CITY OF PORTLAND BUILDING PERMIT

PERMIT ID: 2013-00030

186 SEASHORE AVE, Peaks Island

has permission to **Remove existing deck, add 10'7" x 18'5" single story addition, add full second floor, add deck & covered porch**

**A** Site Plan  
1/6" = 1'-0"

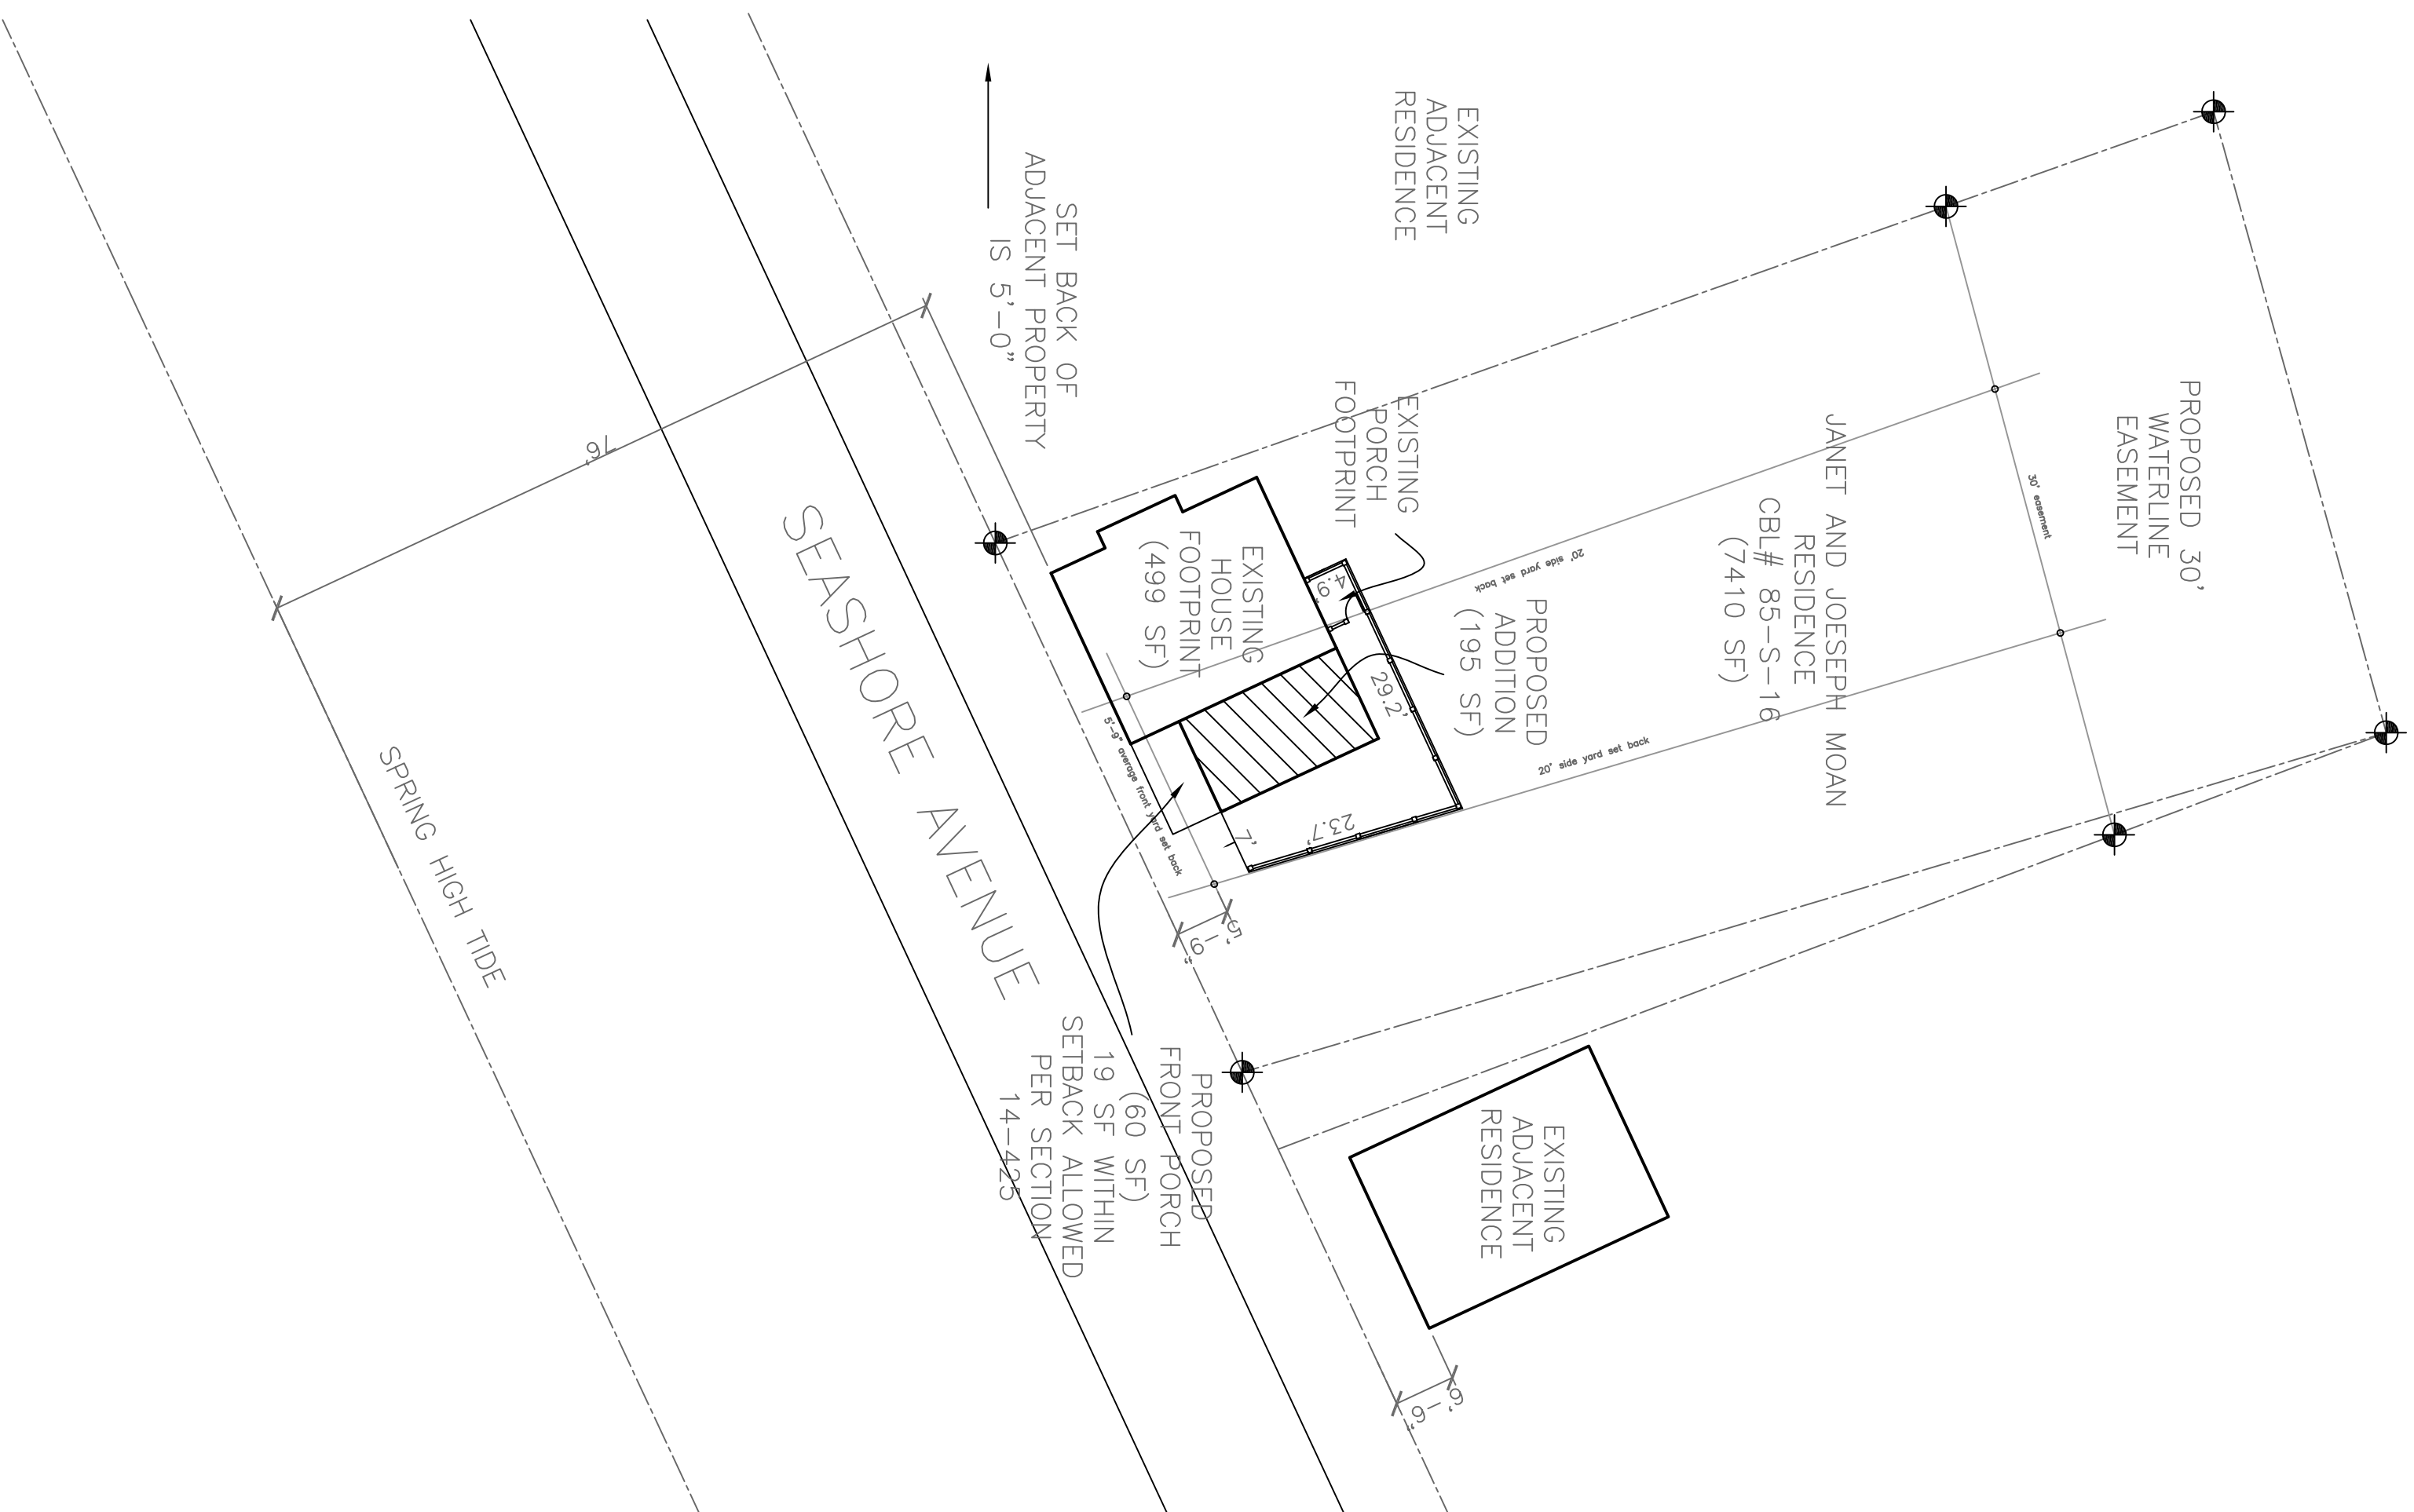
OK using section 14-436' encroaches 1.5 x 10.5 = 15'

Front Yard - 25' or average - average is 5.75' - addition is 10' (OK)

Rear Yard - 25' min - 67' to 30' easement (OK)

Side Yard - 20' - left side - existing footprint (14') right side - 20' to new deck. (OK)

499	existing footprint
349	
<hr/>	
848	234.5
	<hr/>
	848 = 27.7% increase

Roof Framing

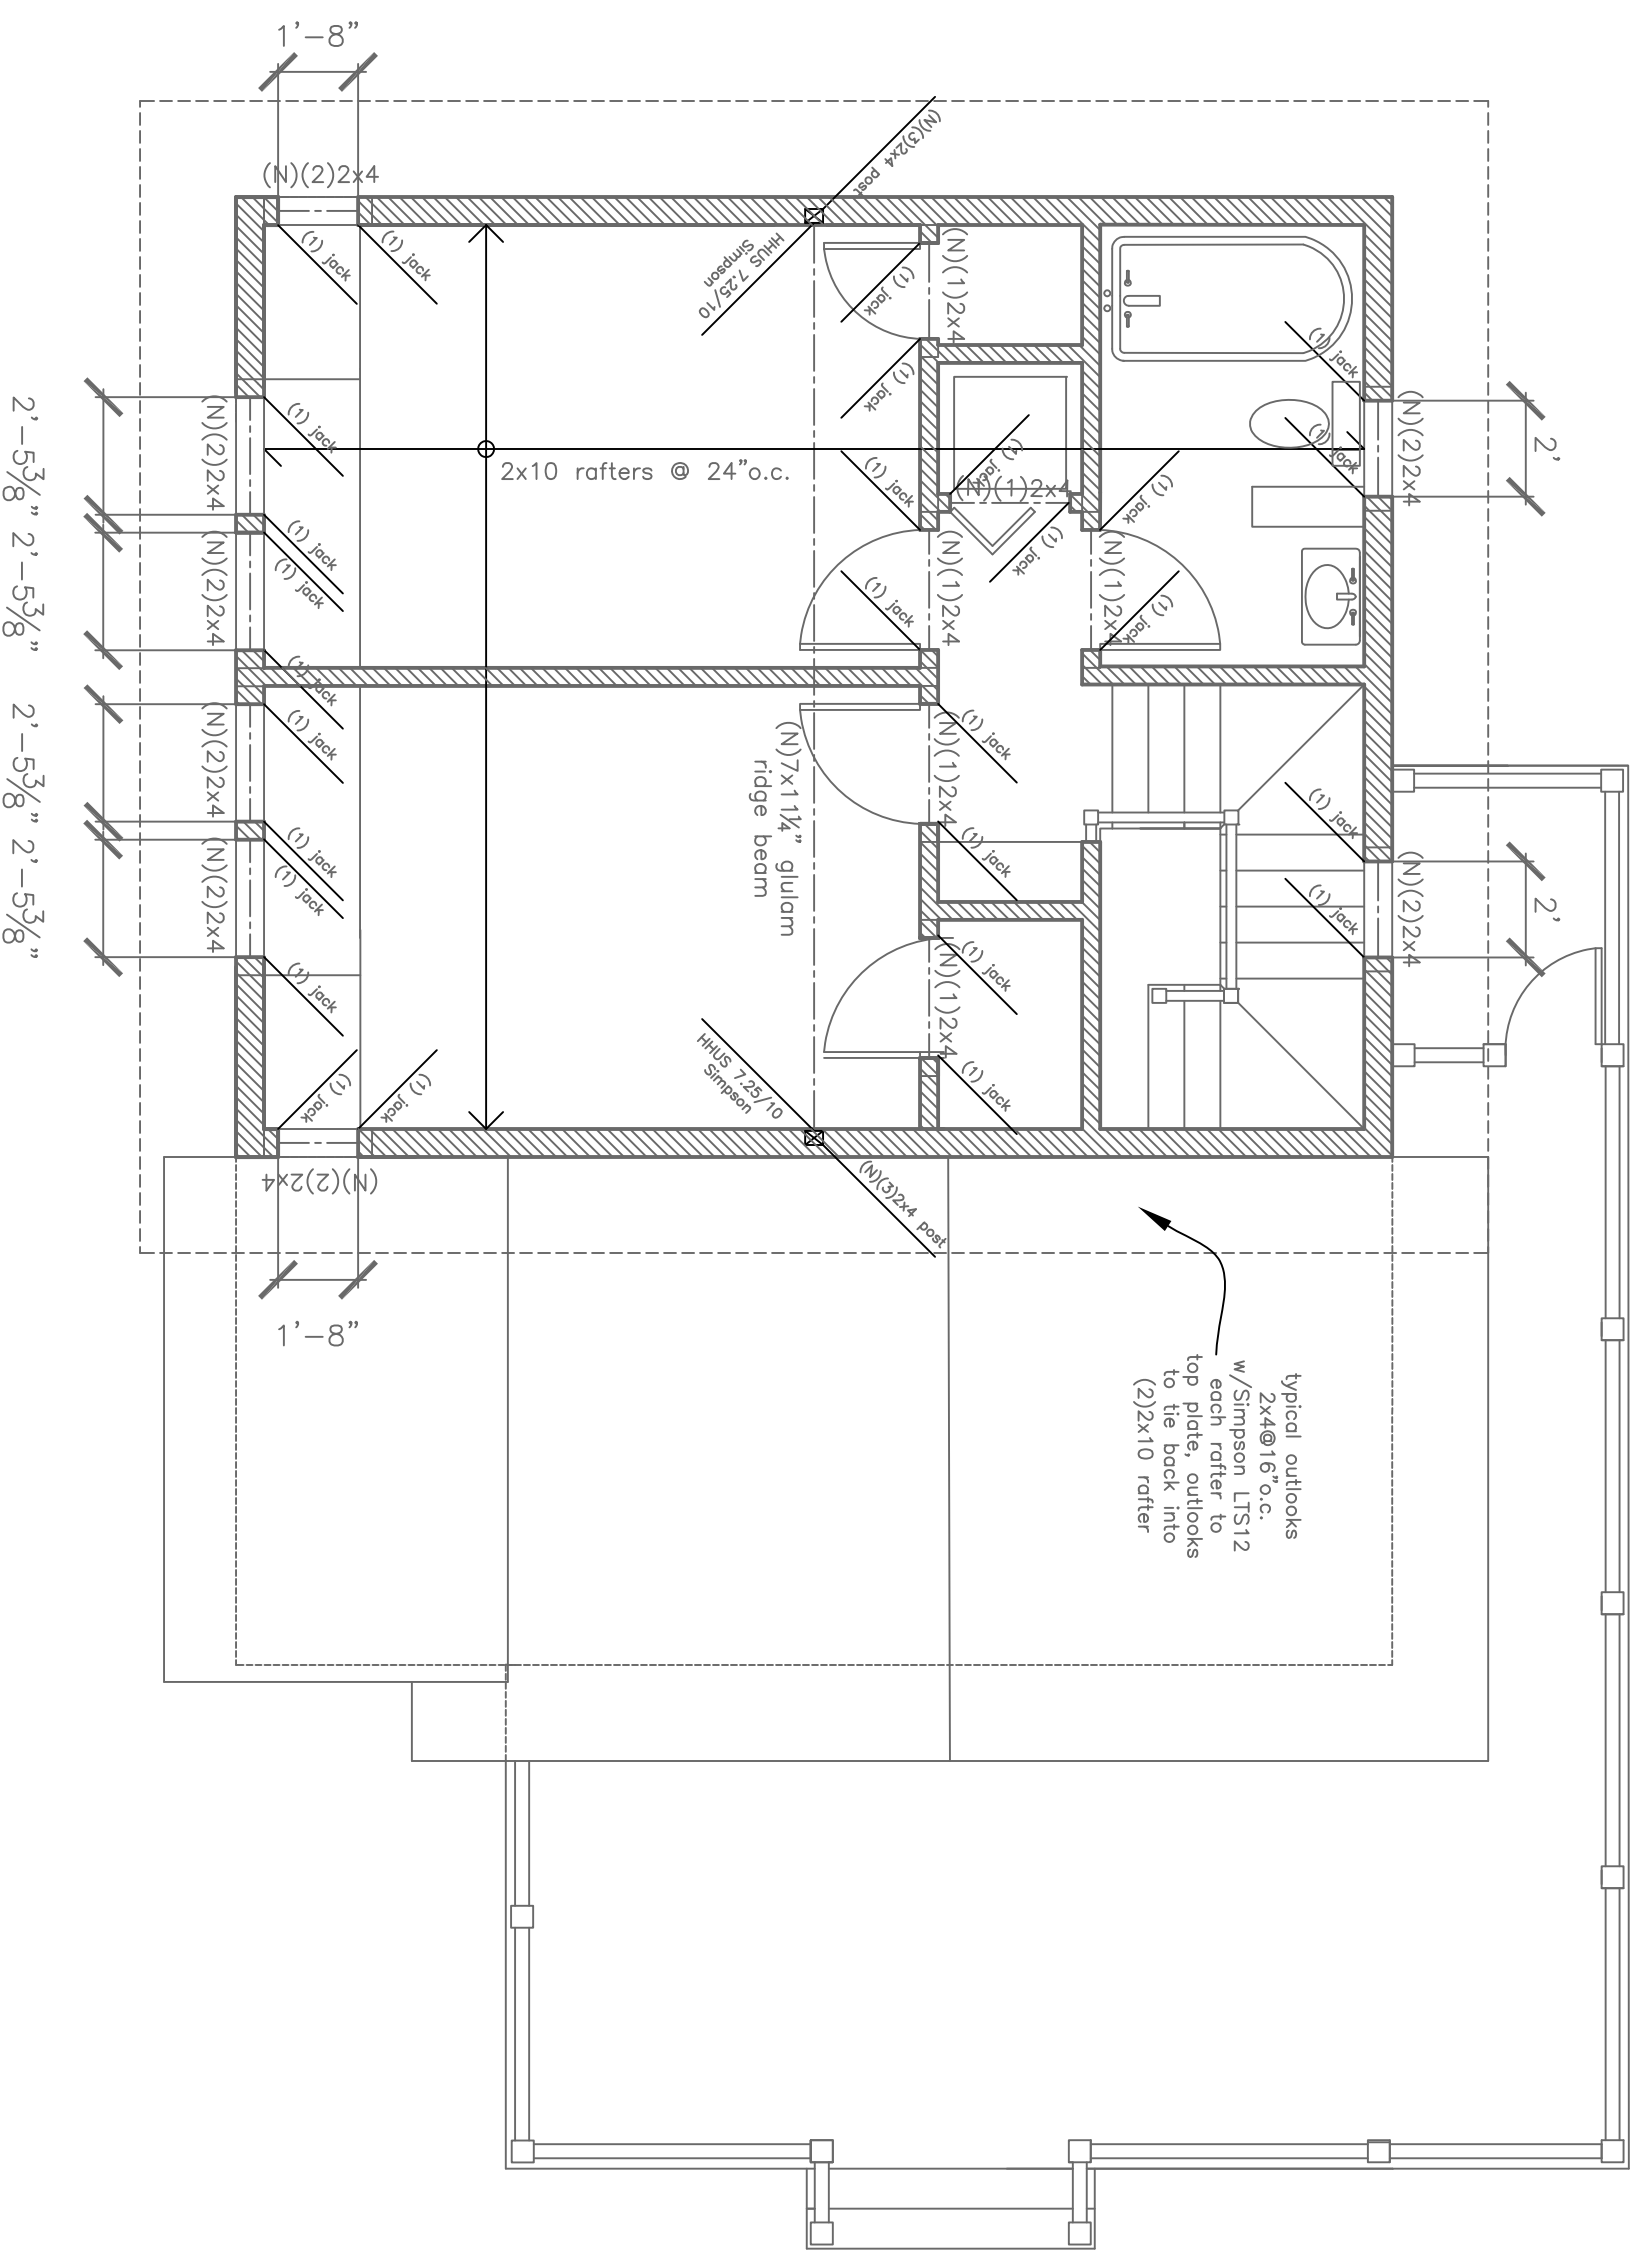
5) The outdoor shower must be plumbed to sanitary drainage system of the structure.			
6) As discussed, the structural ridge beam in the addition shall be 3- 2" x 12"-s or an engineered beam.
